From: Amanda Scholes on behalf of Planning.Responses
Sent: 09 July 2014 10:53
To: planning@southdowns.gov.uk; Amanda Scholes
Subject: FW: Planning Consultation on EG/48/14/DOC

APPLICATION EG/48/14/DOC
NO:

Registered: 08-JUL-14
Site Address: The Barnham Hotel 28 Barnham Road Barnham PO22 0ES

Description of Works: Application for approval of details reserved by condition 6 of previously approved planning application EG/30/13 - relating to surface water drainage

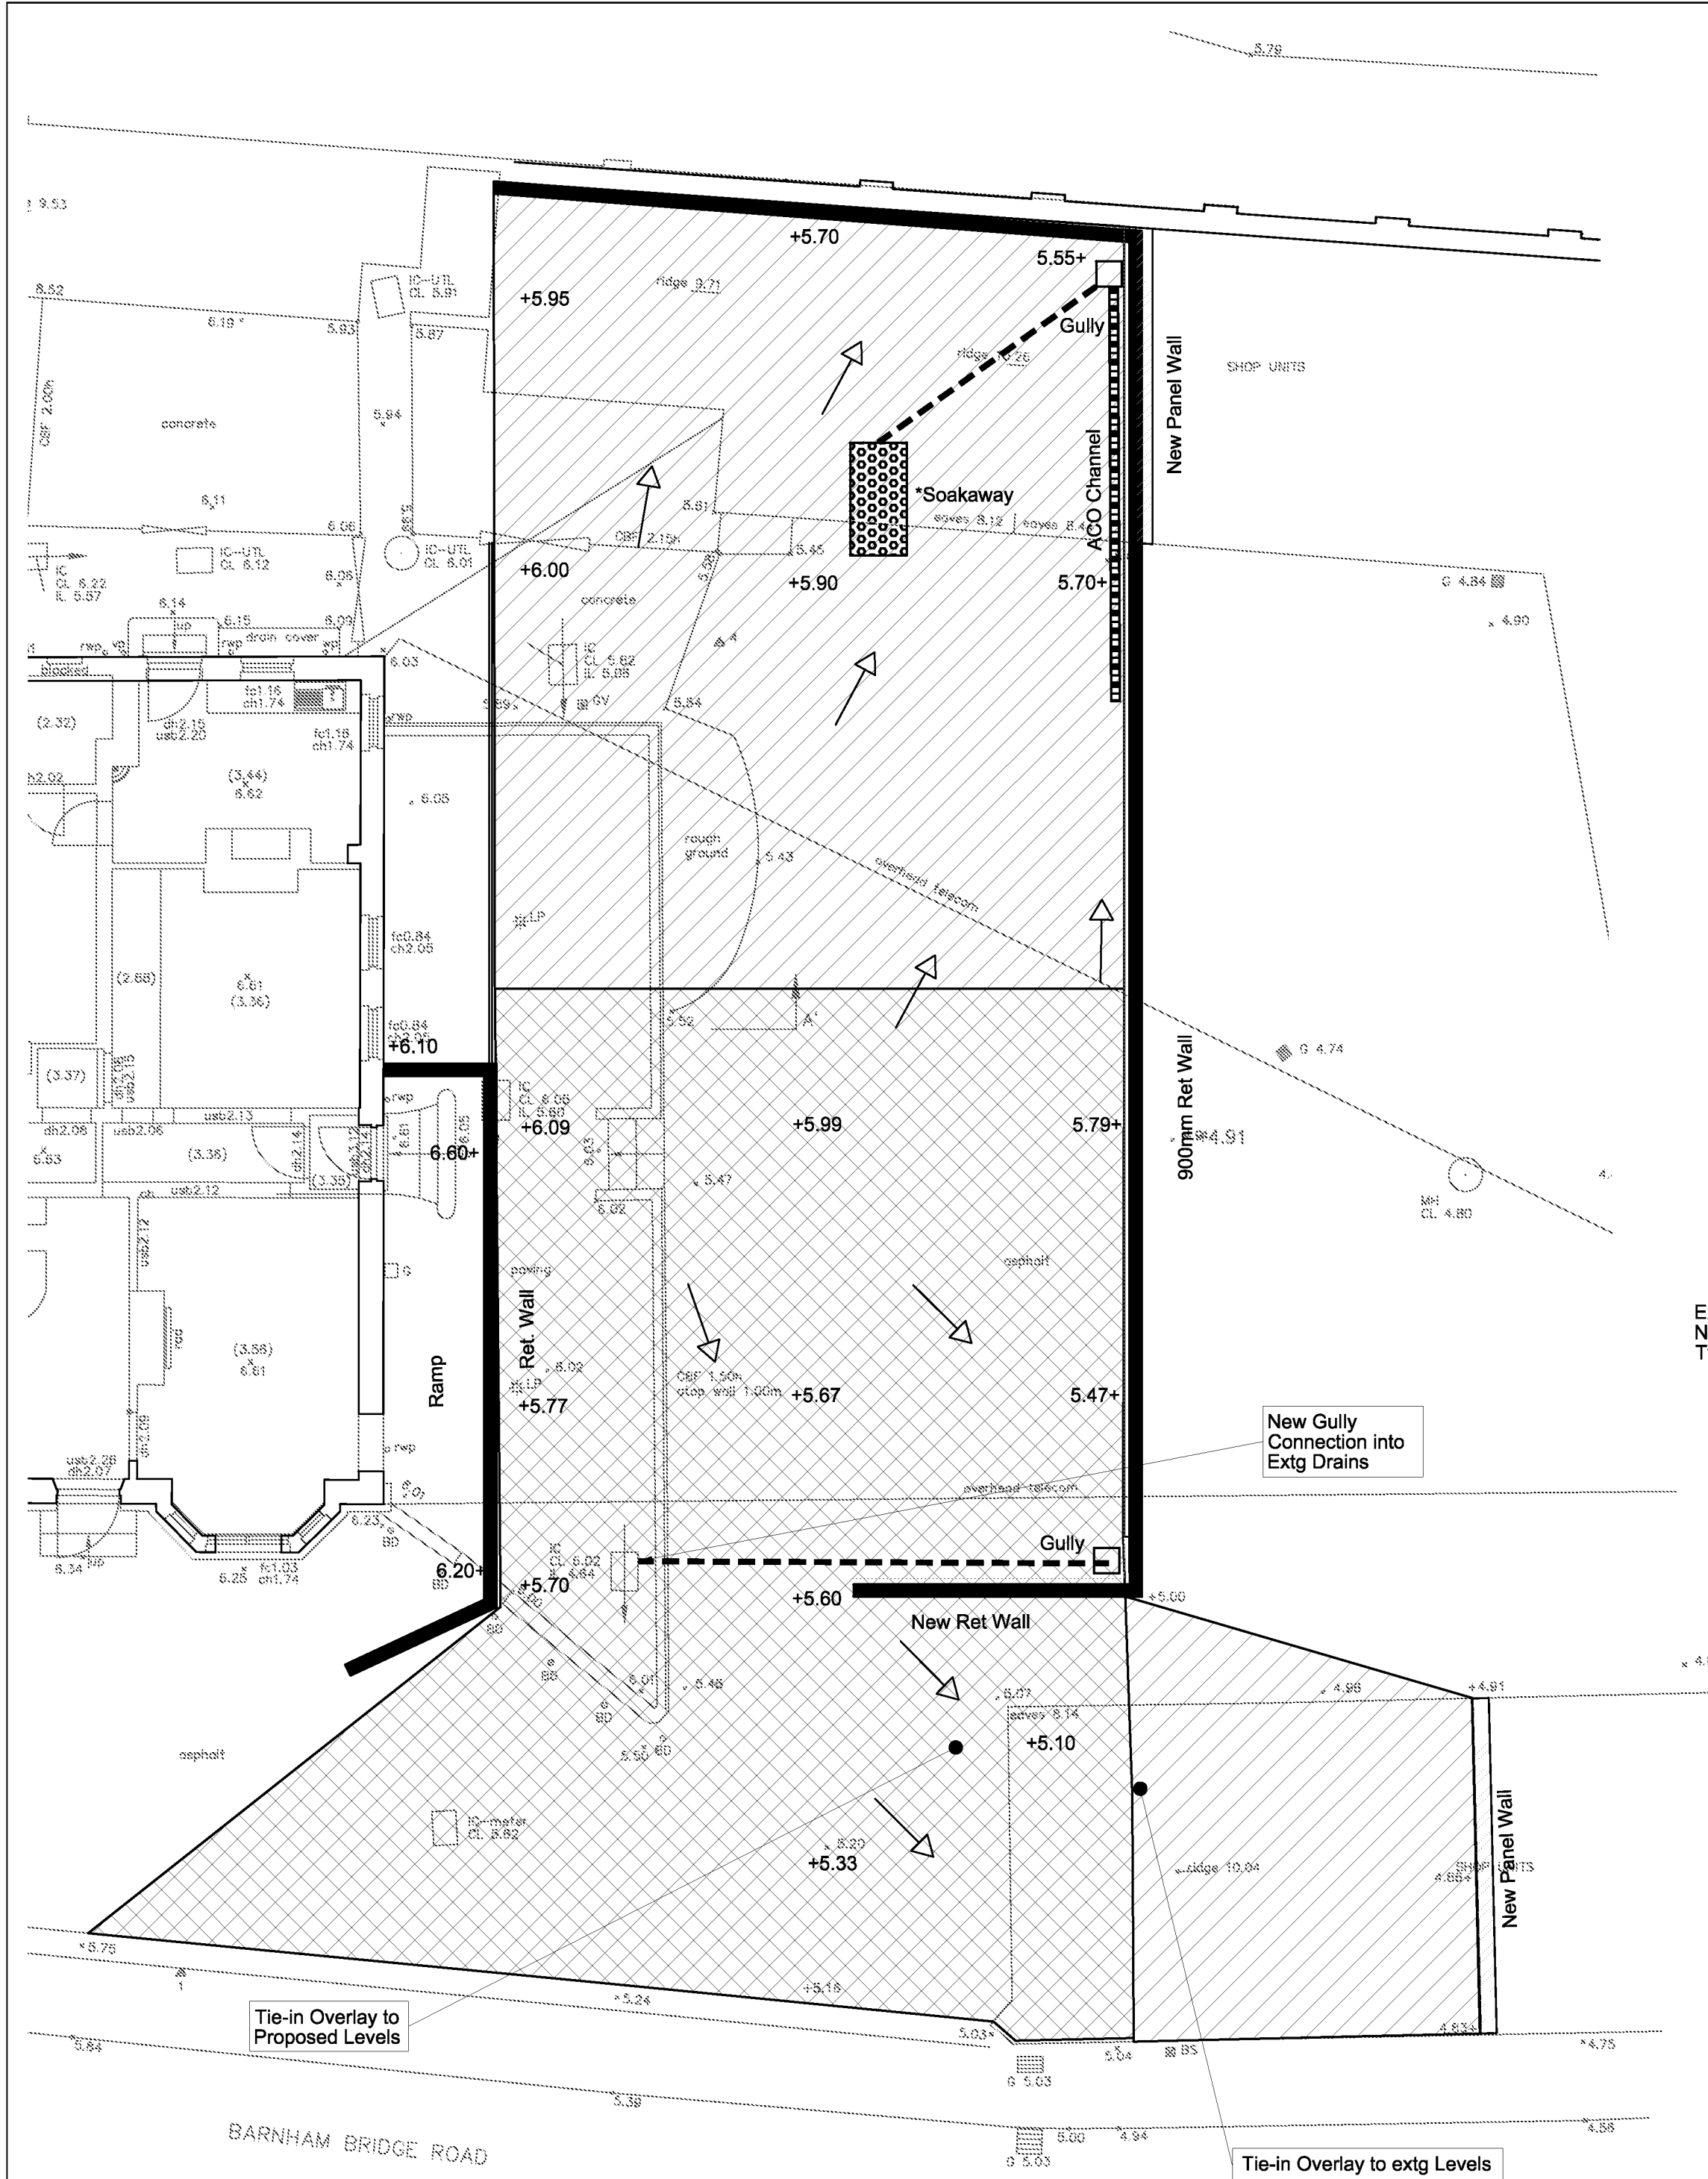
We require calculations showing that the soakaway can contain the 1 in 100 year storm event plus 30% from the additional impermeable areas, BRE 365 results for the infiltration rate and also winter groundwater monitoring to show that the soakaway will not be inundated when the water table is at its highest.

Yes this should be shown as they are affecting the way surface water will flow by reprofiling the hardstanding. It should show any connections to manholes etc

Sorry I missed your call. They have now tried soakaway tests which were unsuccessful. The drainage will be similar to existing, an additional gully is required due to reprofiling of the hardstanding but this will connect into the existing system. As there is hardstanding existing already we can now only treat this as no real change from existing as soakage will not work at this location.

I have since queried the need for the extra gully and have had the following: *"Yes this should be shown as they are affecting the way surface water will flow by reprofiling the hardstanding. It should show any connections to manholes etc"*.

I have forwarded your email to our drainage engineer and he has advised that the current civil engineering scheme already shows the information to include an extra gully/connection to manhole.

Therefore, I consider, if you amend your submitted plan to include the extra gully/connections to manholes etc, then I will be able to approve the condition.
